Application for a non-material amendment following a grant of planning permission.

Unit:		House number:		House suffix:	
House name:					
Address 1:	BARNHAM COMMUNITY HALL				
Address 2:	YAPTON ROAD				
Address 3:					
Town:	BARNHAM				
County:					
Postcode (optional):	PO22 0BD				
Description of location or a grid reference. (must be completed if postcode is not known):					
Easting:		Northing:			
Description:

REPLACEMENT VILLAGE HALL WITH THE ERECTION OF A TERRACE OF
4 NO 2 BED HOUSES AND 4 NO 3 BED HOUSES ON FORMER
VILLAGE HALL SITE

BN / 3 / 09

Project Name/Address:
**Residential Development at
Barnham Community Hall Project
Yapton Road
Barnham**
Client Name:
Burton Property
Drawing Title:
3–Bed Terrace Cottages

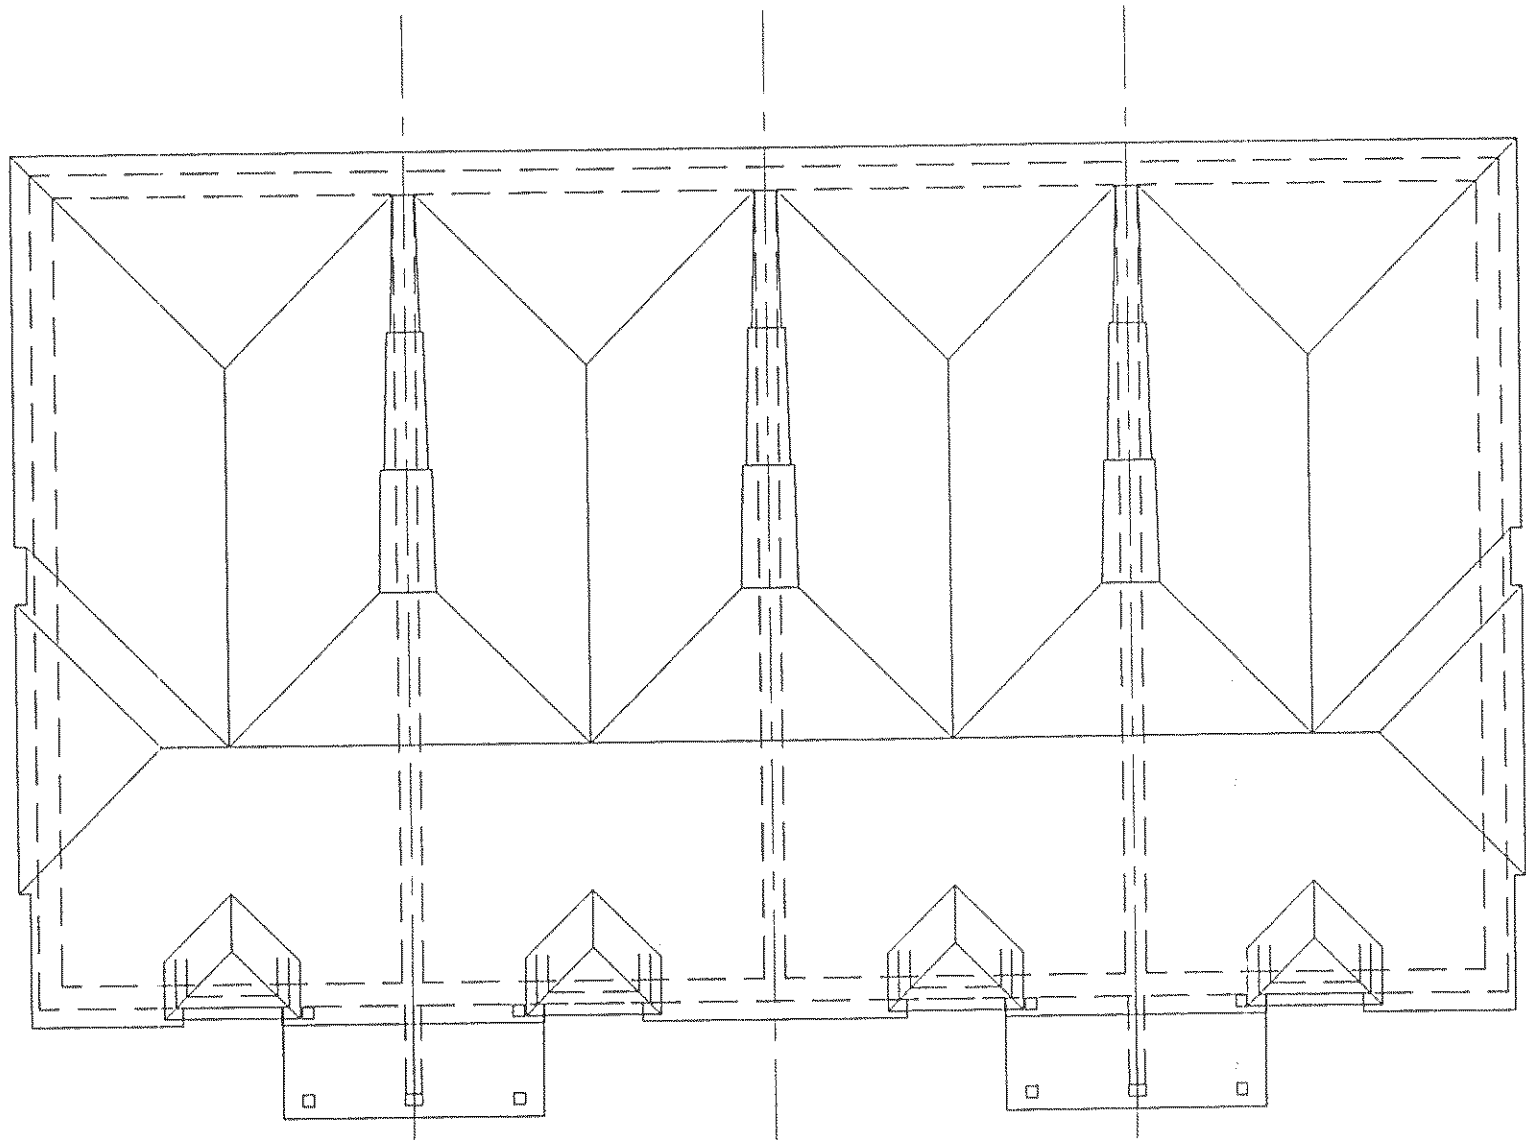
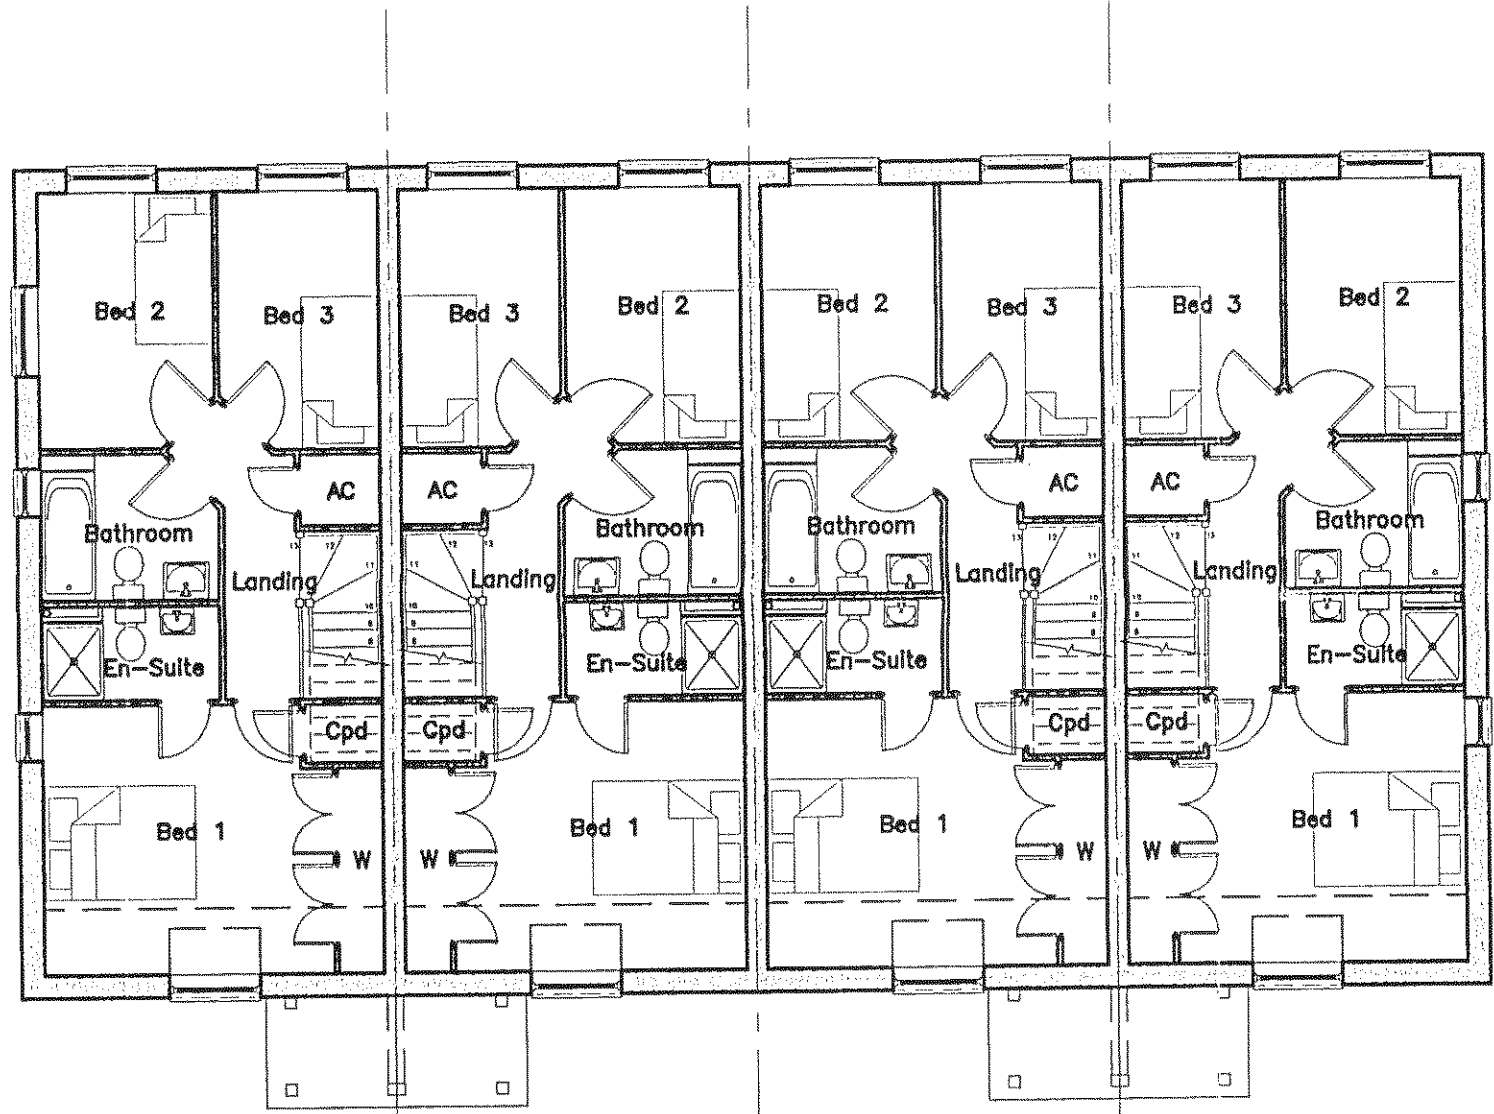
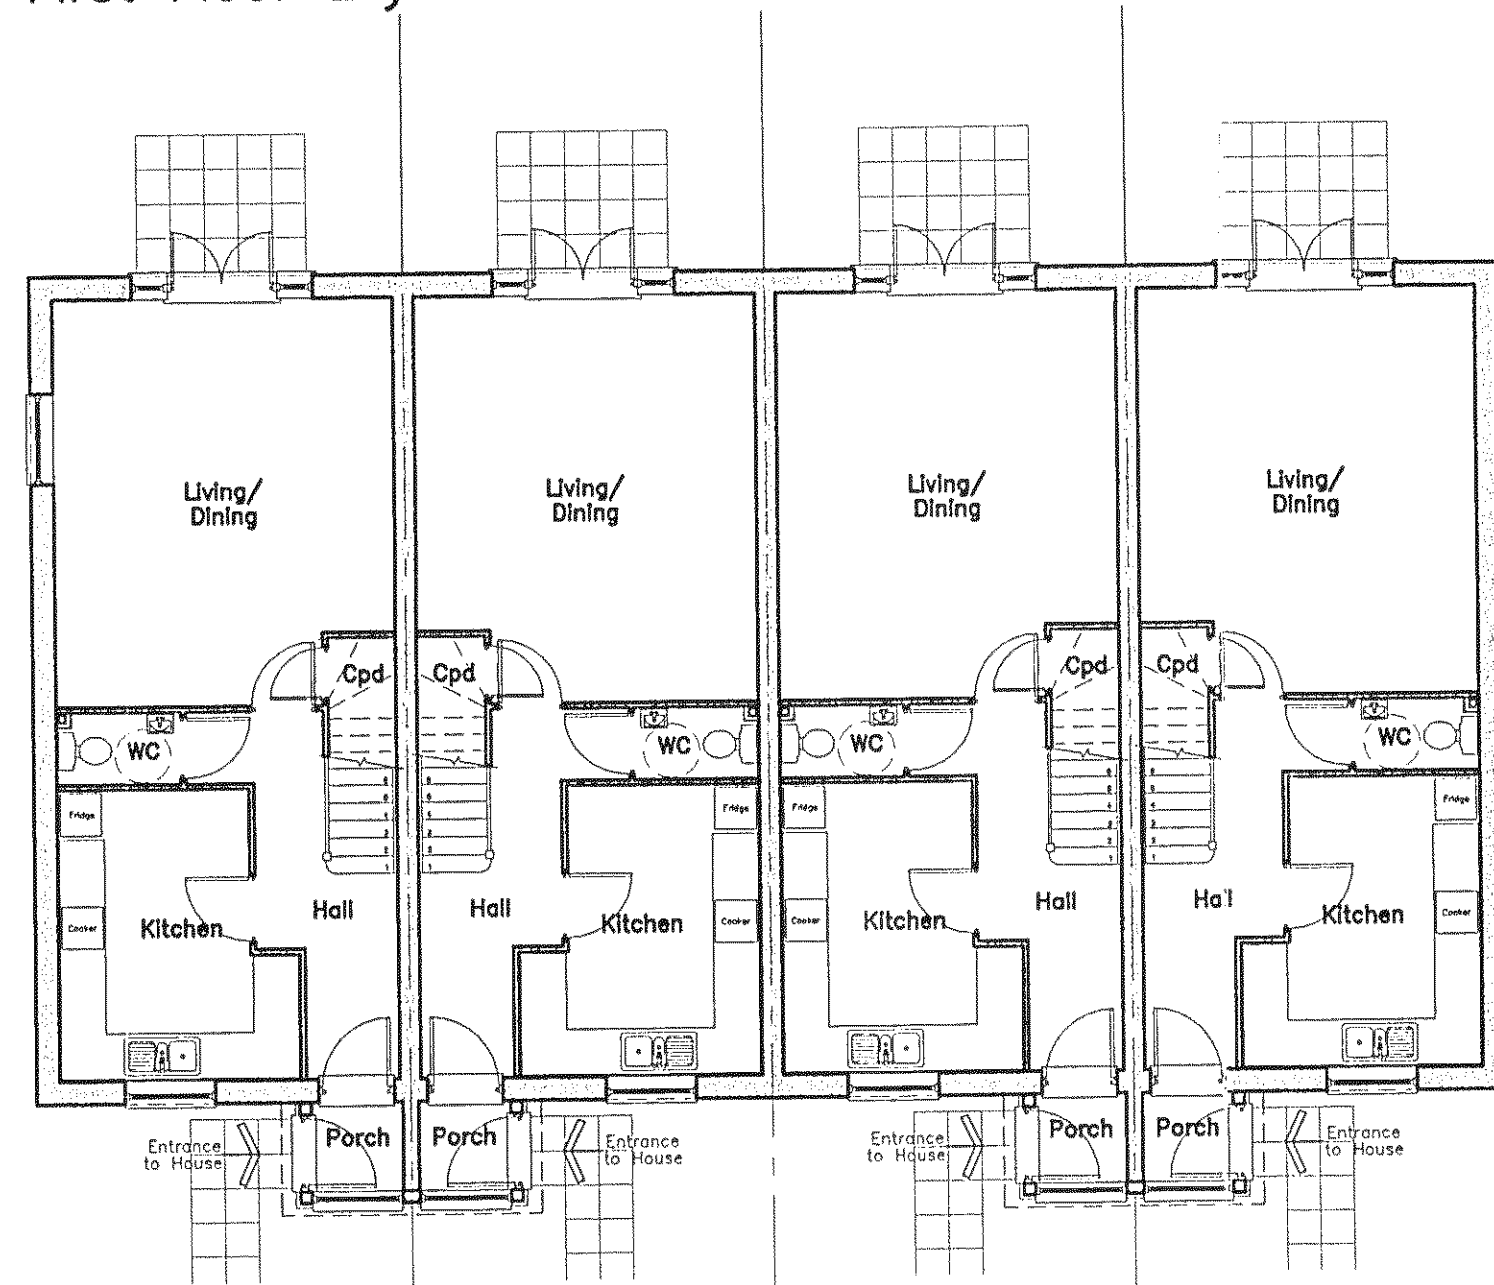
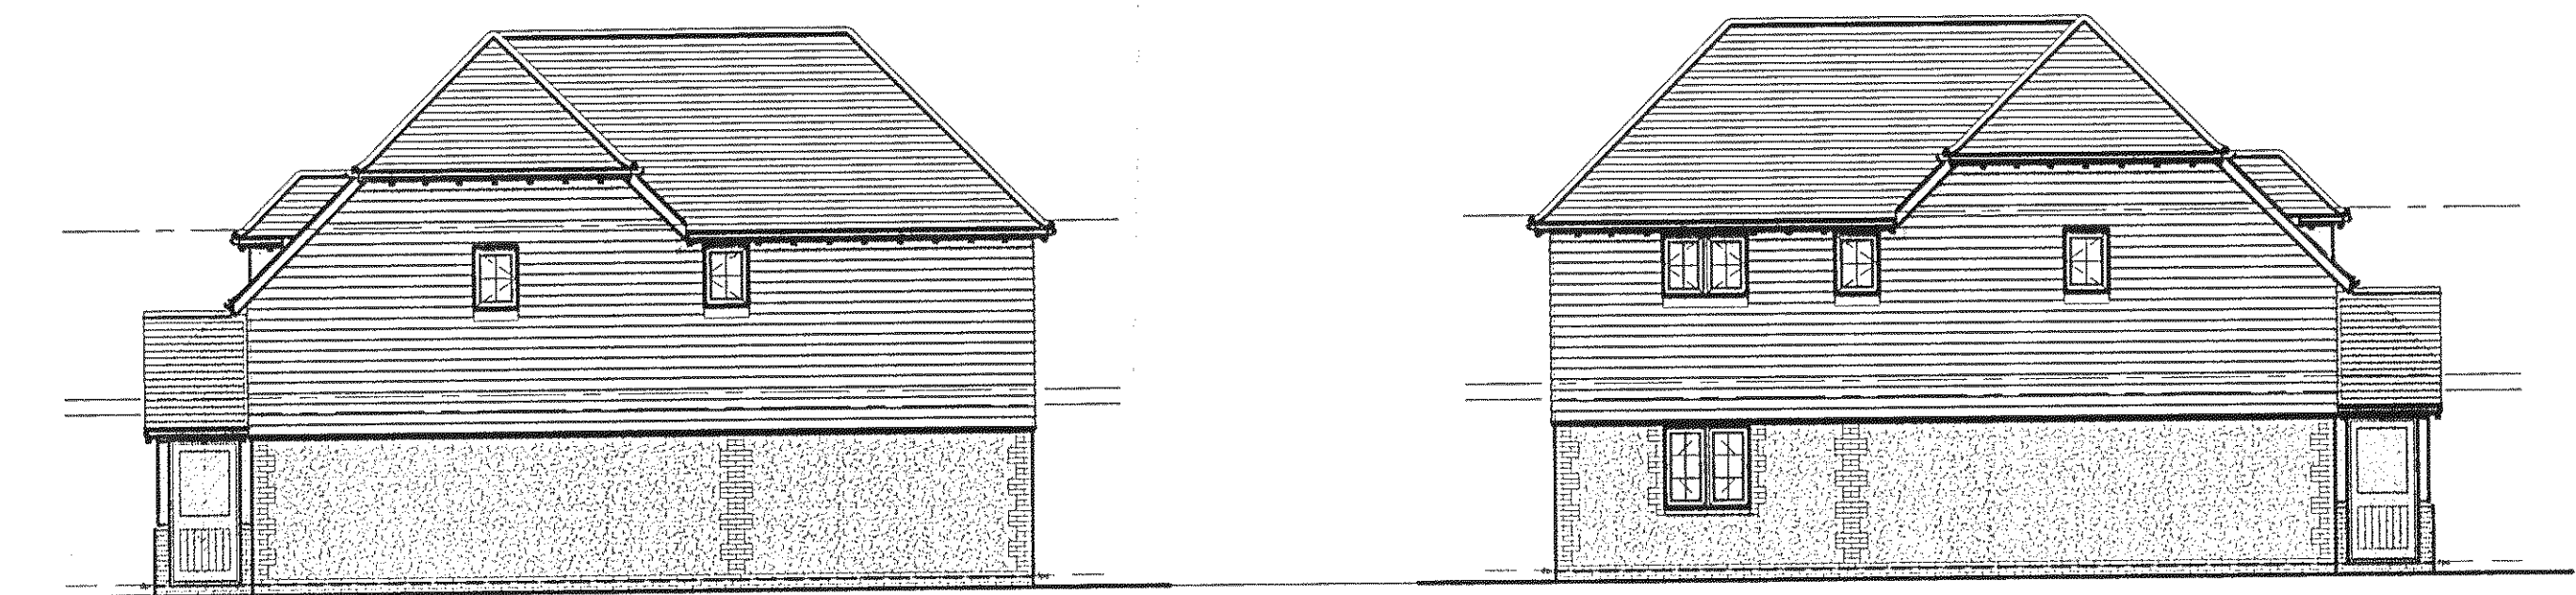
MINOR CHANGES TO PRECISE LOCATION OF THE FIRST FLOOR WINDOWS
IN BOTH EAST AND WEST END / SIDE ELEVATION TO BOTH TERRACES
(PLOTS 1 AND 4 ; 5 AND 8) - HOUSING ELEMENT.

1/ TO IMPROVE THE INTERNAL ARRANGEMENTS OF THE PROPOSED
LIVING ACCOMMODATION, AND
2/ TO REGULARISE ON A CLEARER MORE ACCURATE PLAN THE
SITE LAYOUT ARRANGEMENTS.

Drawing Title:
Site Plan/External Works

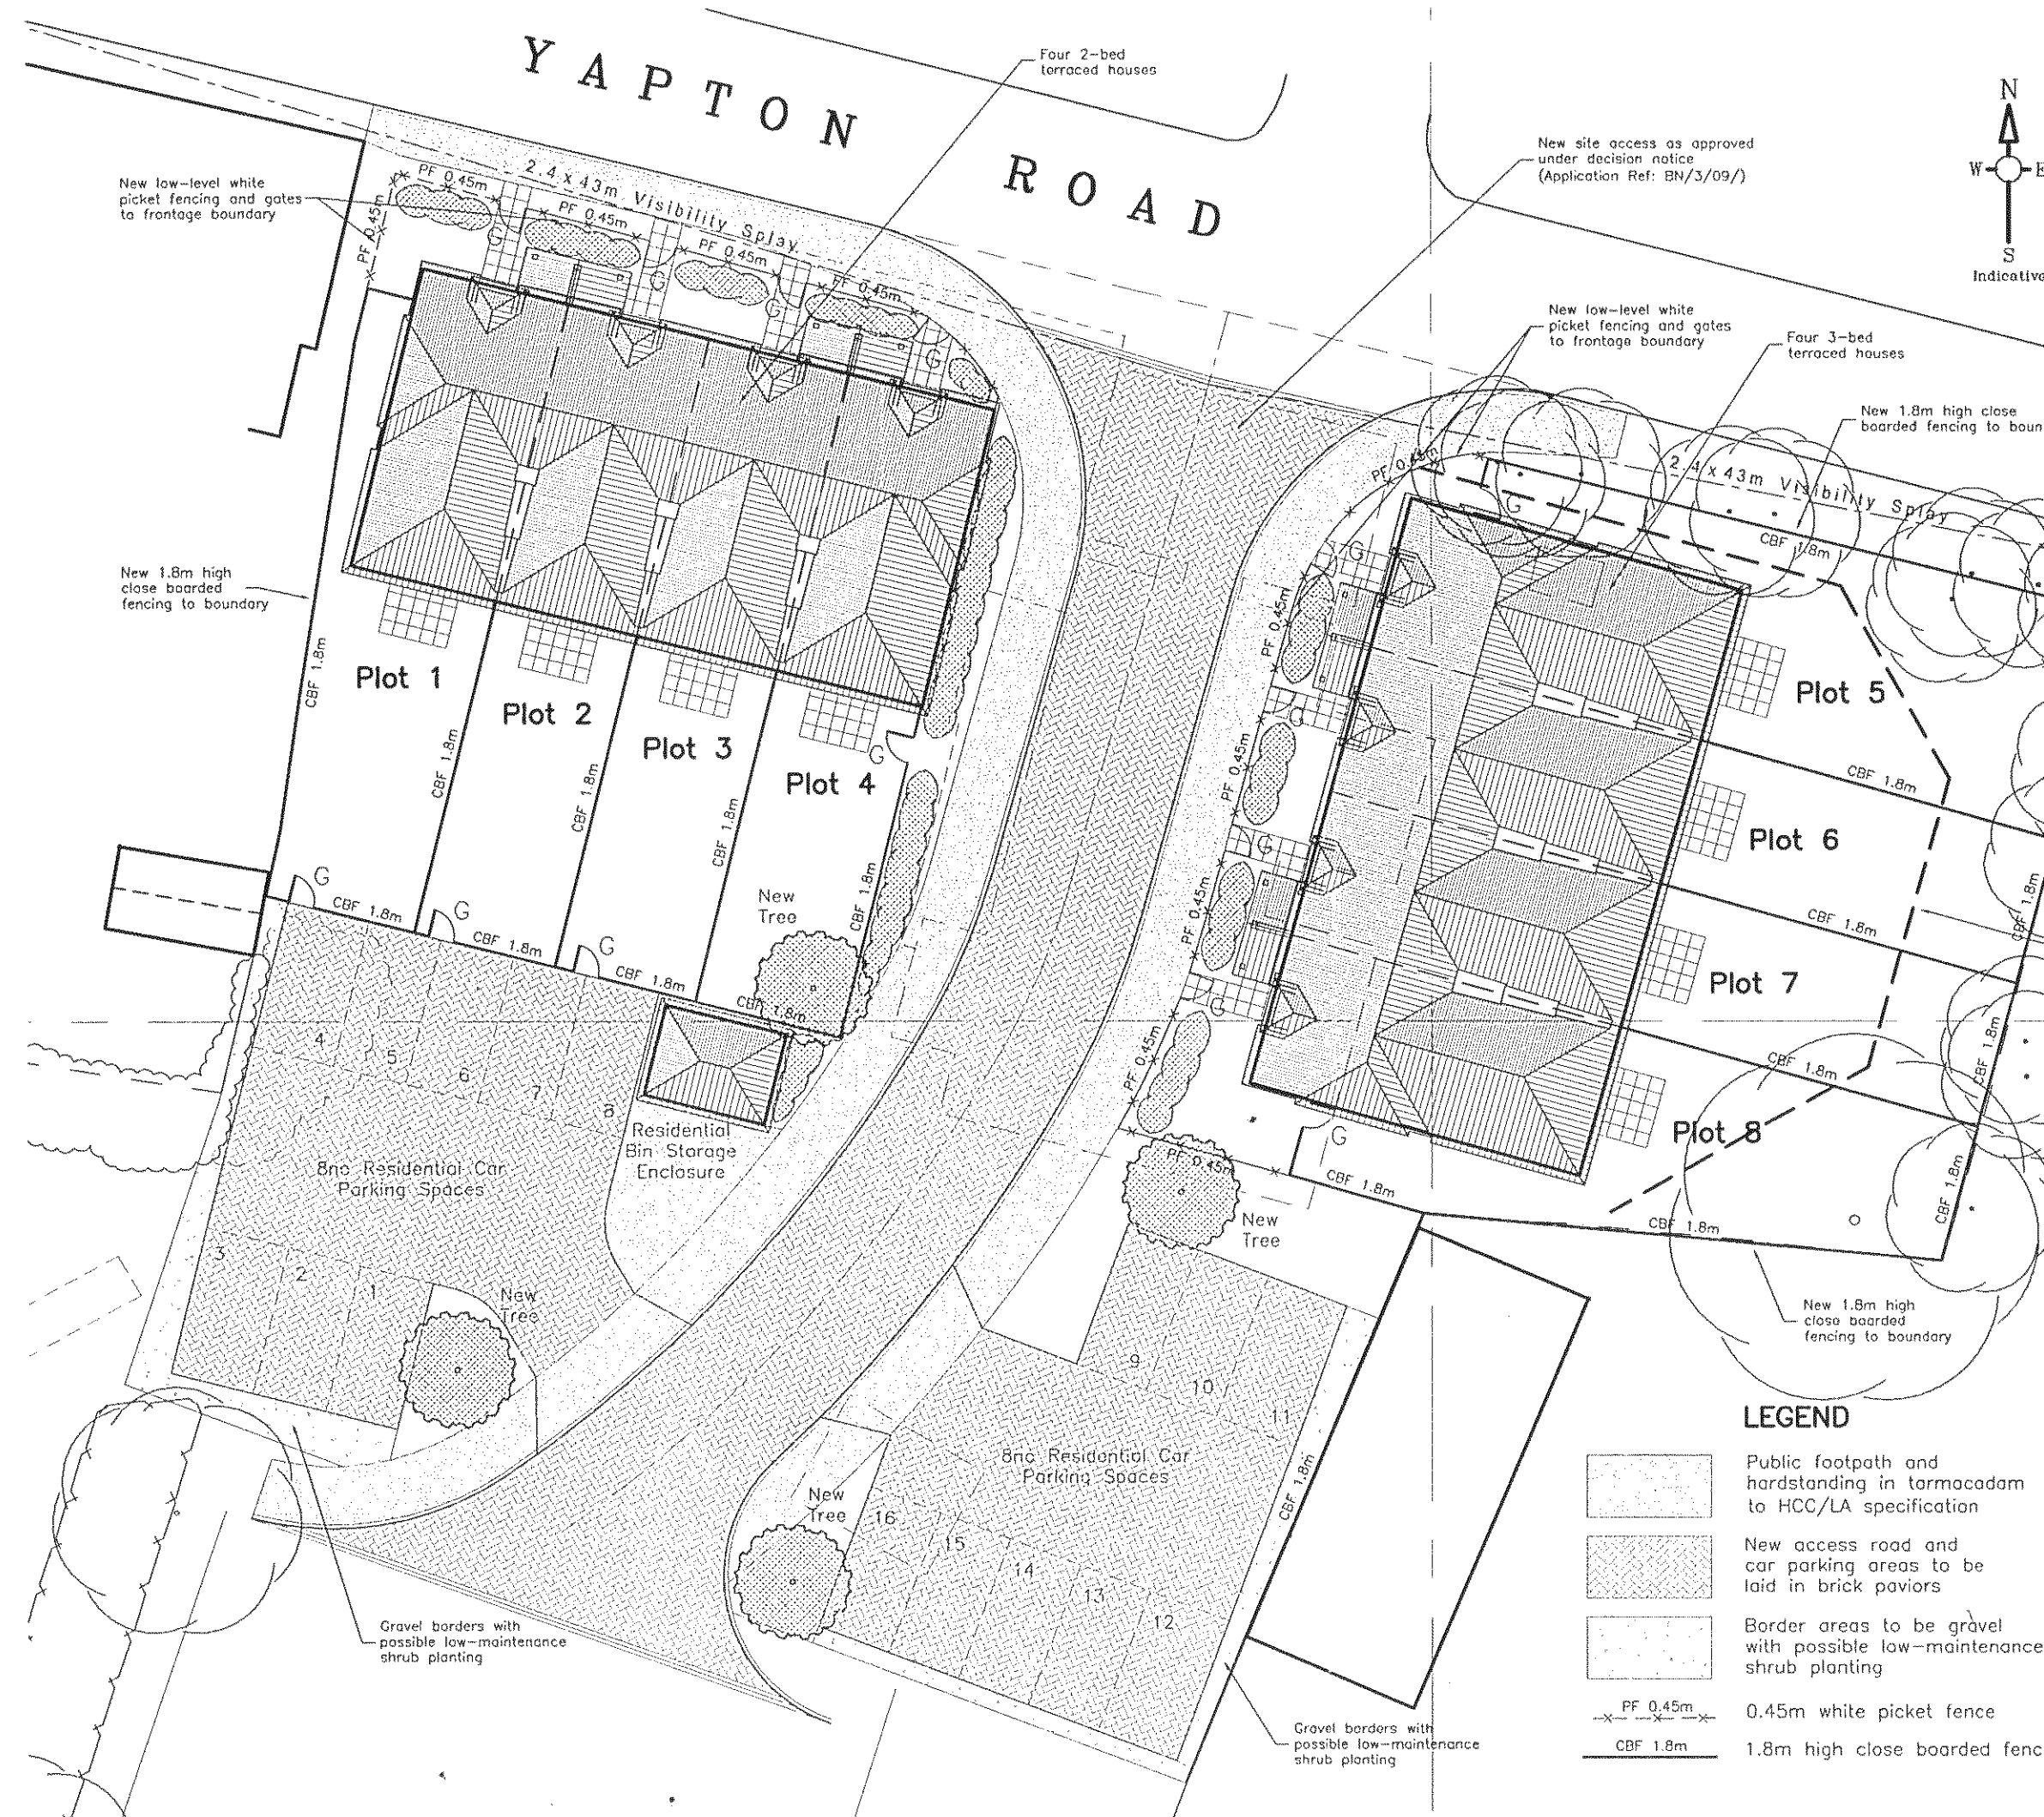
A MORE DETAILED SITE LAYOUT PLAN PRECISELY SHOWING
THE LAYOUT AND EXTERNAL ARRANGEMENTS + AN INTERNAL
WORKS LAYOUT SHOWING PROPOSED HARD AND SOFT TREATMENTS
TO BE READ IN CONJUNCTION WITH TGD LANDSCAPE PLAN 1912-101
SUBMITTED TODAY TO DISCHARGE CONDITION 11
